CUMNOR PARISH COUNCIL

BOTLEY WEST SOLAR FARM (BWSF) REF: EN010147

1. Cumnor Parish Council's Assessment of the Applicant's 25 late submissions

1.1. C1-108 Outline Residential and Visual Amenity Plan (oRVAP)

APPENDIX A | LANDSCAPE PARAMETER PLAN

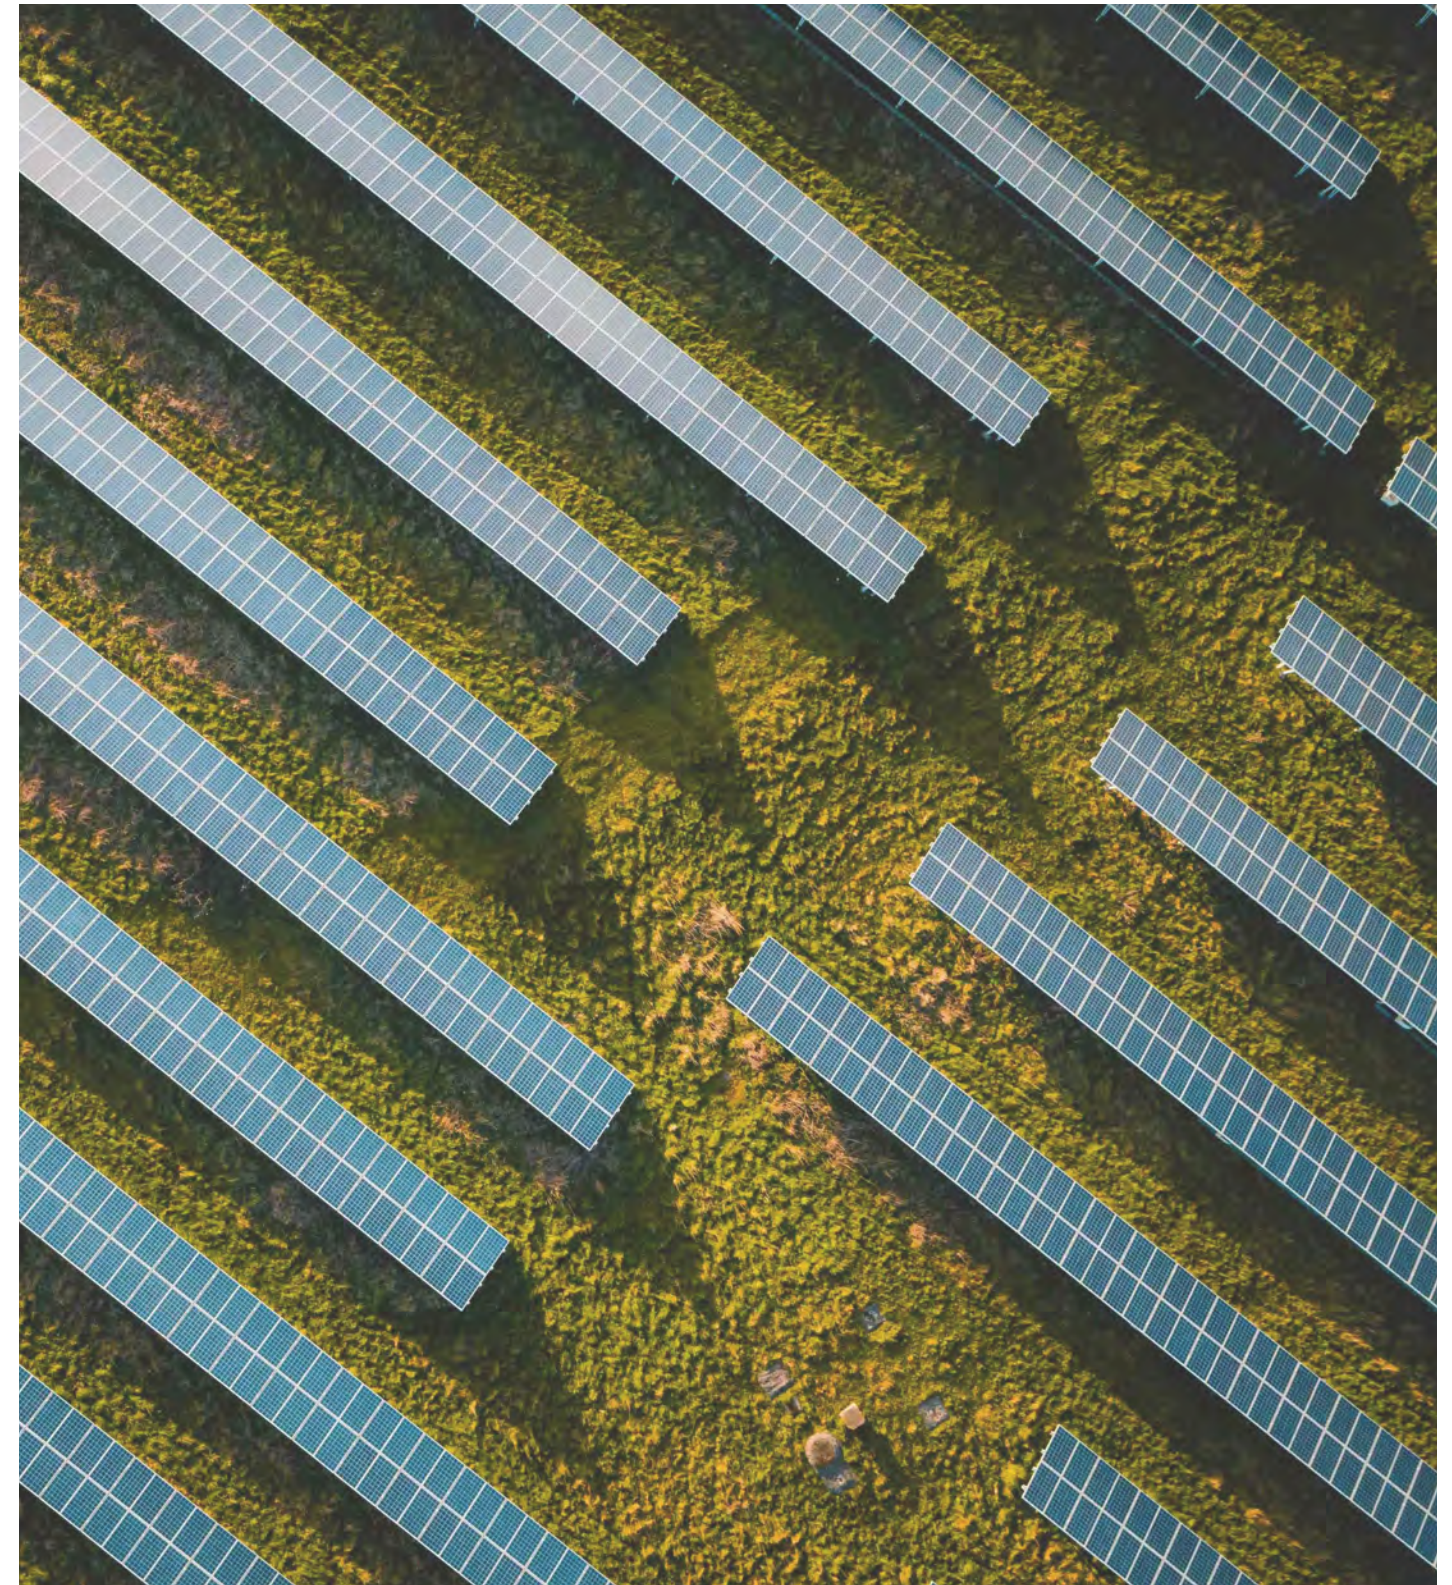
The latter of course, as the July 16th late submission of the 'Landscape Parameter Plan' (C1-110) shows on Sheet 13a (see image 1 above) with the substation and its infrastructure (referred to as Works 3a and 2) in situ where the Applicant has always placed them. Quelle surprise!

52 - Denman’s Farm

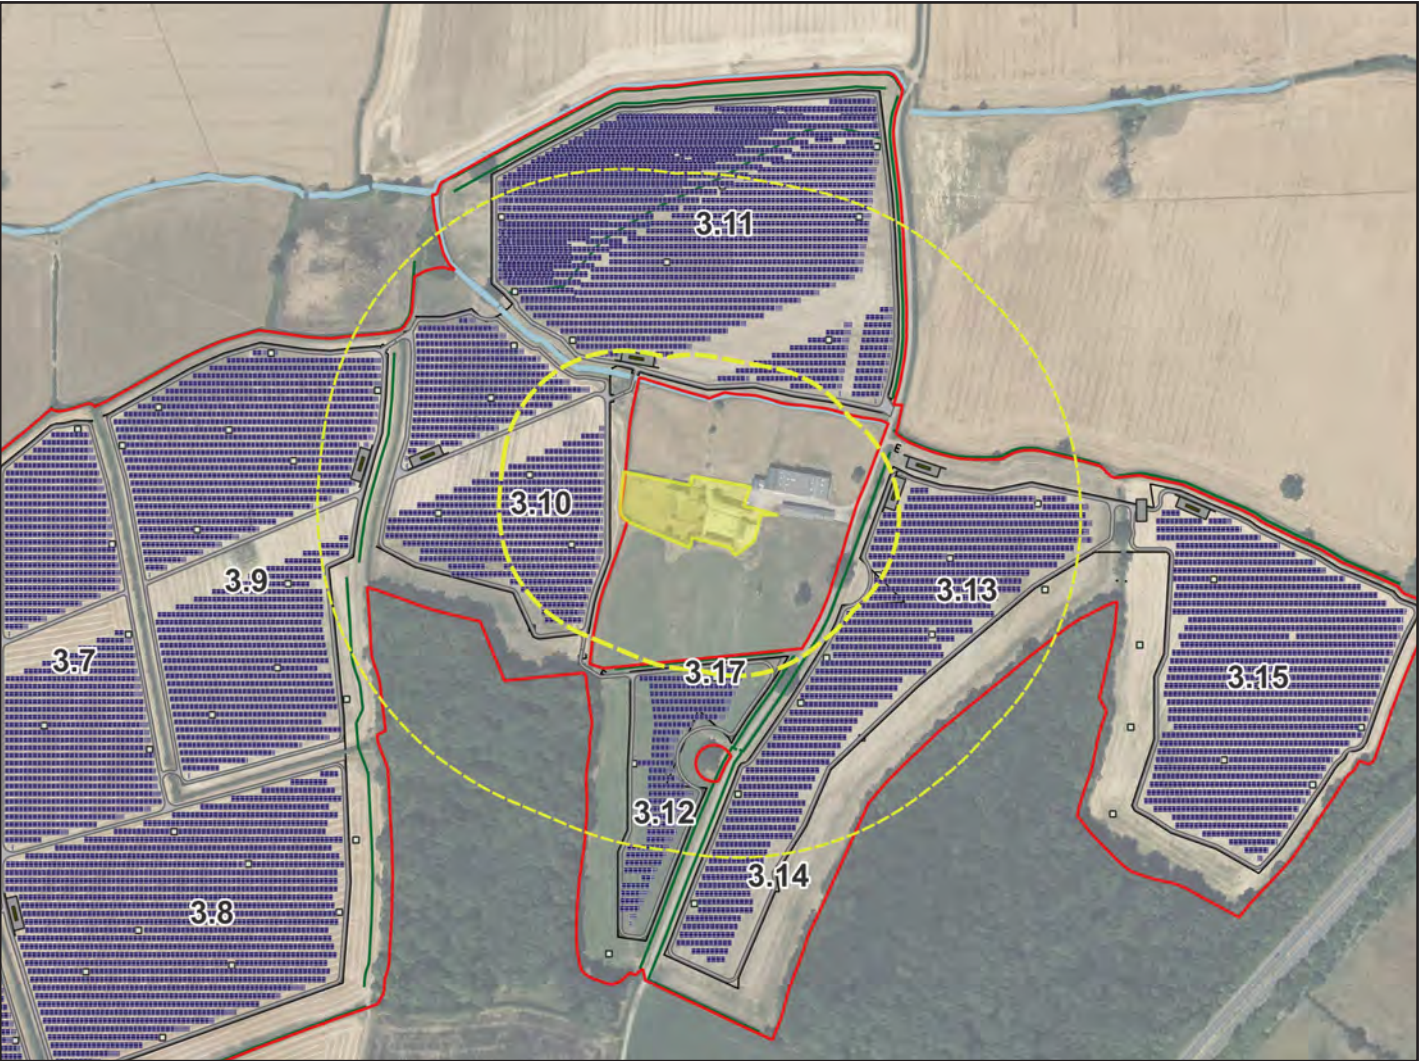
- Notwithstanding the newly proposed 100m buffer, p63 of **C1-108** attempts to justify a 14m buffer for Denman's Farm. Even this strains the envelope of truth since the 14m is not measured from the curtilage as required (Landscape Institute Guidance Note 2/19), but from the outside wall of the residential properties on that site. In fact, the buffer would be effectively zero since the curtilage is surrounded on all sides by Fields 3.10-3.14 and 3.17.
- Page 65 of **C1-108** repeats this flawed evidence and assessment process. The buffer for Jumpers farm is now shown to be 70m – so less than 100m – but again not measured from the curtilage but from a more tightly drawn perimeter.
